Rezoning Transportation Analysis

Petition Number: 2020-137

| Date | Description |
|----------|--------------|
| 10-26-20 | First Review |

General Review Information

DATE: 08/11/20	MPIC: WILL
DRAWN BY: DSB	CHECKED BY: WILL
PROJECT NUMBER: 00777.00	
SCALE: 1" = 60'	
TITLE: CONCEPTUAL SITE PLAN

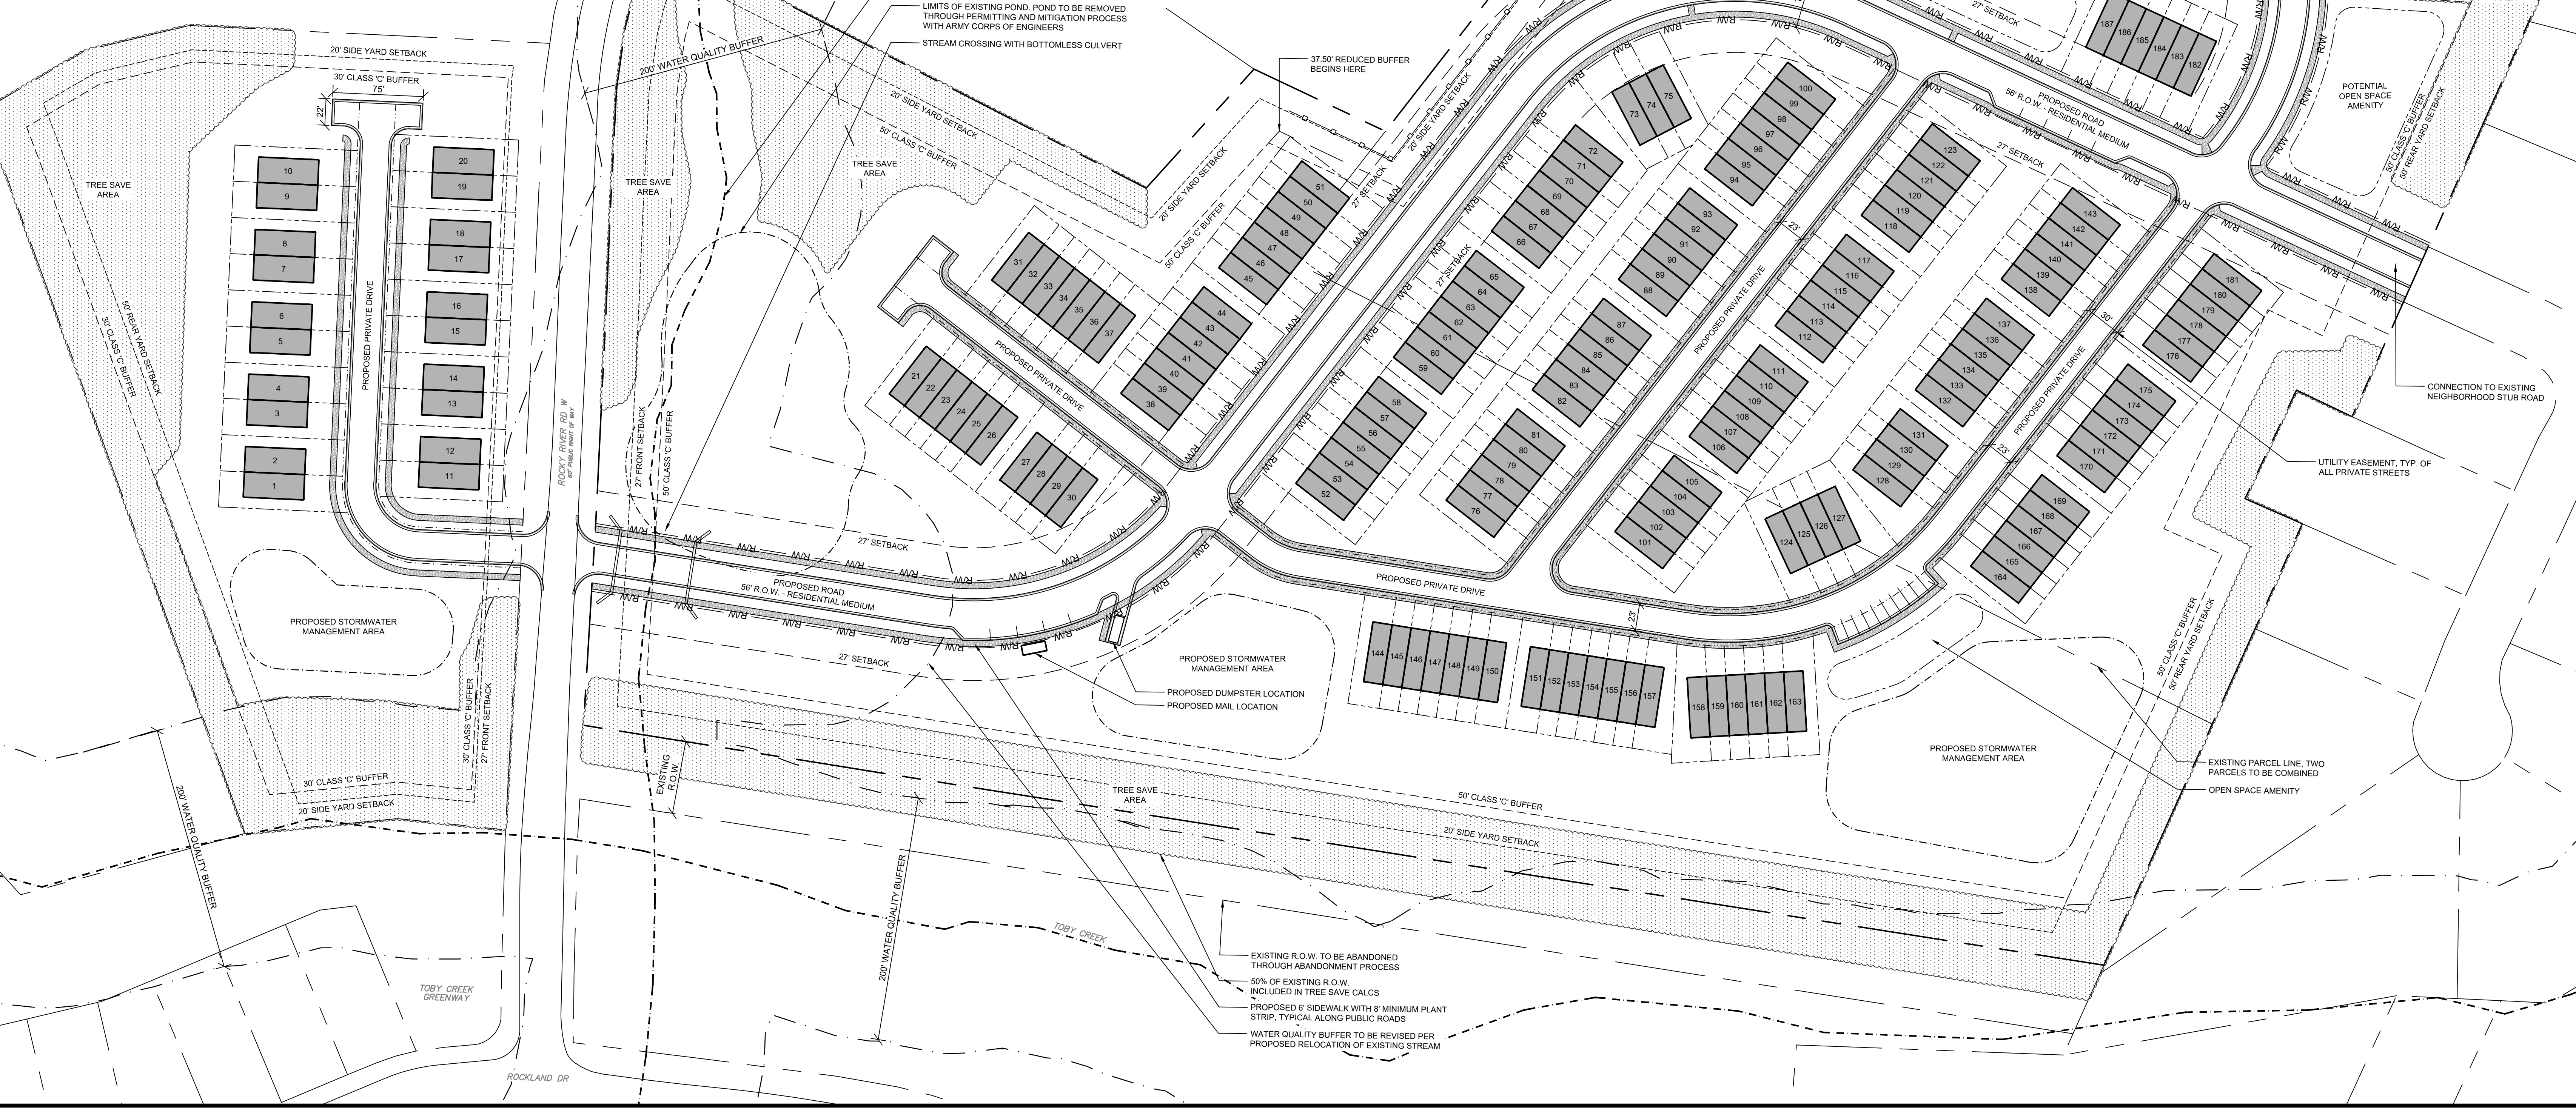
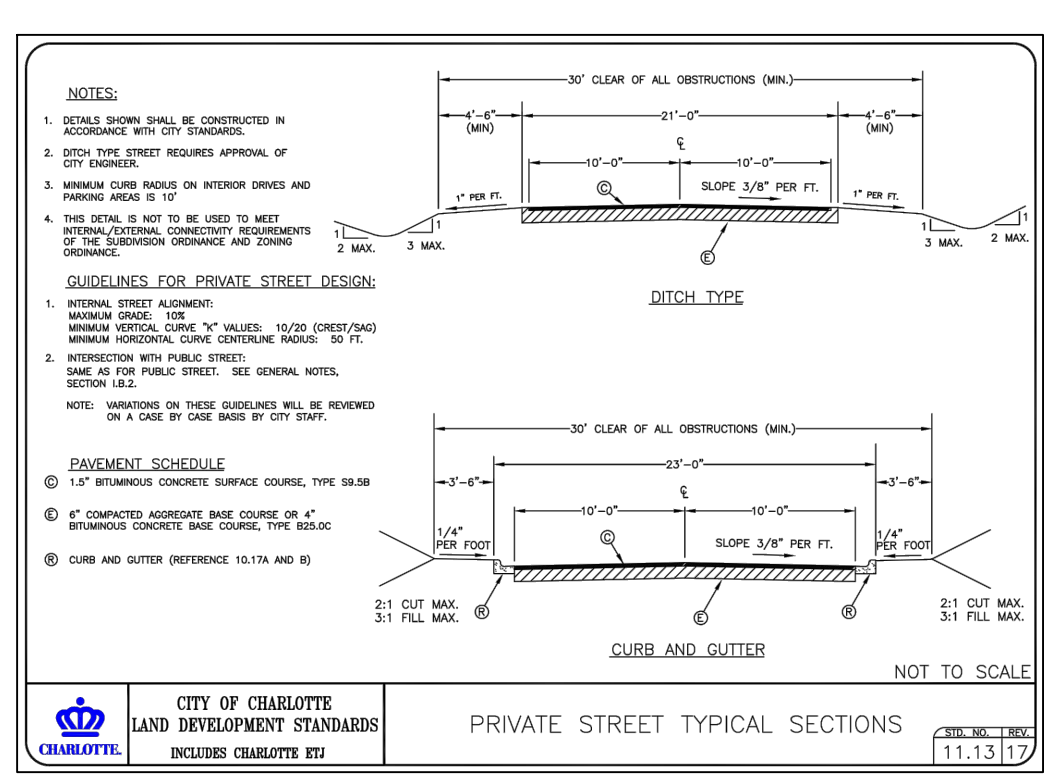
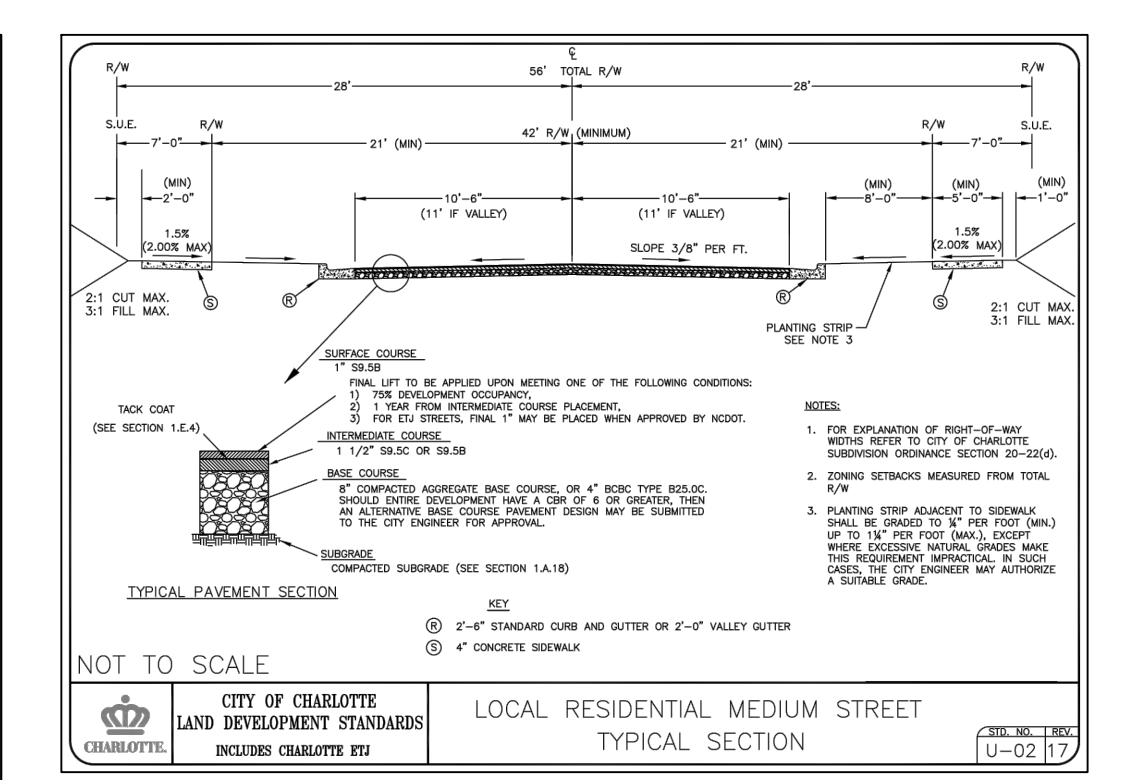
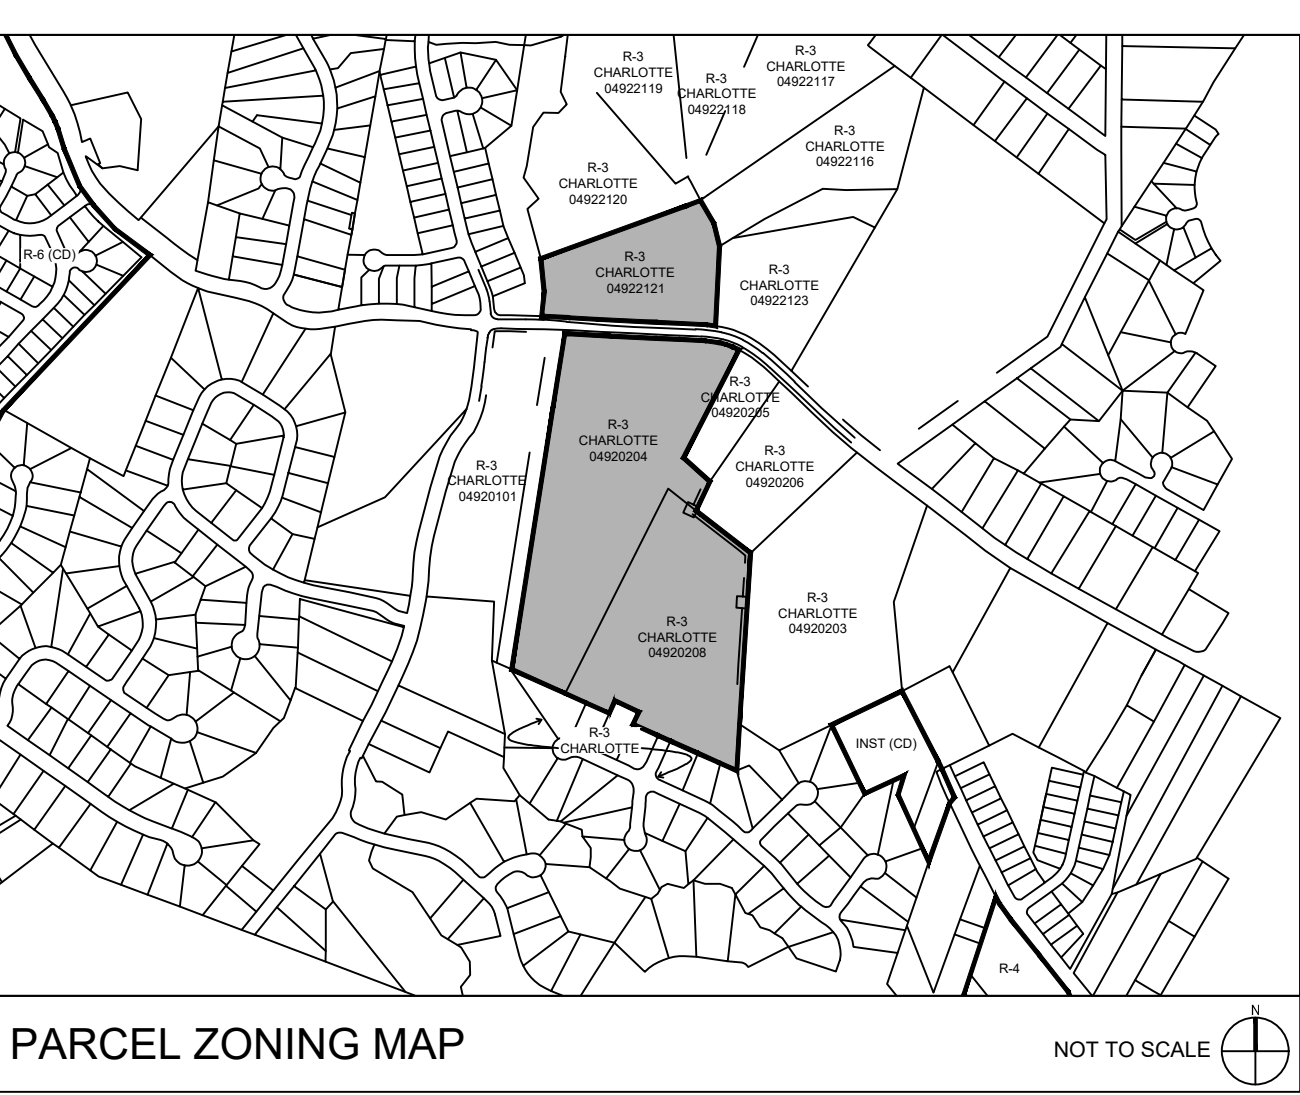
- Curbline:** The proposed zoning district has a setback measured from back of the existing or proposed future curbline.
 - Rocky River Road West:** The back of curb and gutter shall be located at 19' from the roadway centerline. This accounts for two 11' through lanes, 2.5' curb and gutter, and an 11' left turn lane at the site's entrance.

Label and dimension the curb and gutter from the centerline for each road on the site plan.
- Traffic Study:**

A Traffic Impact Study is not necessary for the complete review of this petition due to the site generating less than 2,500 daily trips. If during the permitting process the site generates more than 2,500 daily trips, then a traffic study will be required.
- Revise the site plan and conditional note(s) to commit to dedicating 35' right-of-way from the Rocky River Road West Road centerline. Label and dimension the right-of-way from the road centerline.
- Revise the site plan and conditional note(s) to commit to constructing alley-loaded townhomes along all specified public roads to meet the minimum spacing requirement of 20' per the City of Charlotte Driveway regulation.

- 5. Revise the site plan and conditional note(s) to commit to dedicate 56' right-of-way for Newell View Lane. Label and dimension the right-of-way on the site plan.

- 6. Revise the site plan and conditional note(s) to commit to dedicate connecting the northern development to Newell View Lane while providing a hammerhead at the western limits, reducing conflict points at the Rocky River Road West Intersection.

7. Revise the site plan and conditional note(s) to commit to construct an 8-foot planting strip, and 6-foot sidewalk on the Proposed Public Road as per Chapter 20 and the Charlotte WALKS Policy. Label and dimension both items from the back of curb and gutter and road centerline on the site plan.
8. Rocky River Rd. West is a designated Overland Connector on the Greenway Master Plan. Revise the site plan and conditional note(s) to commit to installing a 12' multi-use path along property frontage with pedestrian structure(s) or culvert extension to provide connectivity and accessibility in accordance with the City of Charlotte BIKE and Charlotte WALKS policies.

9. Revise the site plan and conditional note(s) to commit to providing a left turn lane into the development as required for developments that generate over 500 trips per day.

10. Please add a site plan conditional note specifying dedication and fee simple conveyance of all rights-of-way to the City before the site's first building certificate of occupancy is issued is needed. CDOT requests rights-of-way set at 2' behind back of sidewalk where feasible.
11. Please add a site plan conditional note specifying that all transportation improvements will be approved and constructed before the site's first building certificate of occupancy is issued is needed. The petitioner may phase transportation improvements if said improvements and phasing are explicitly described in site plan notes.
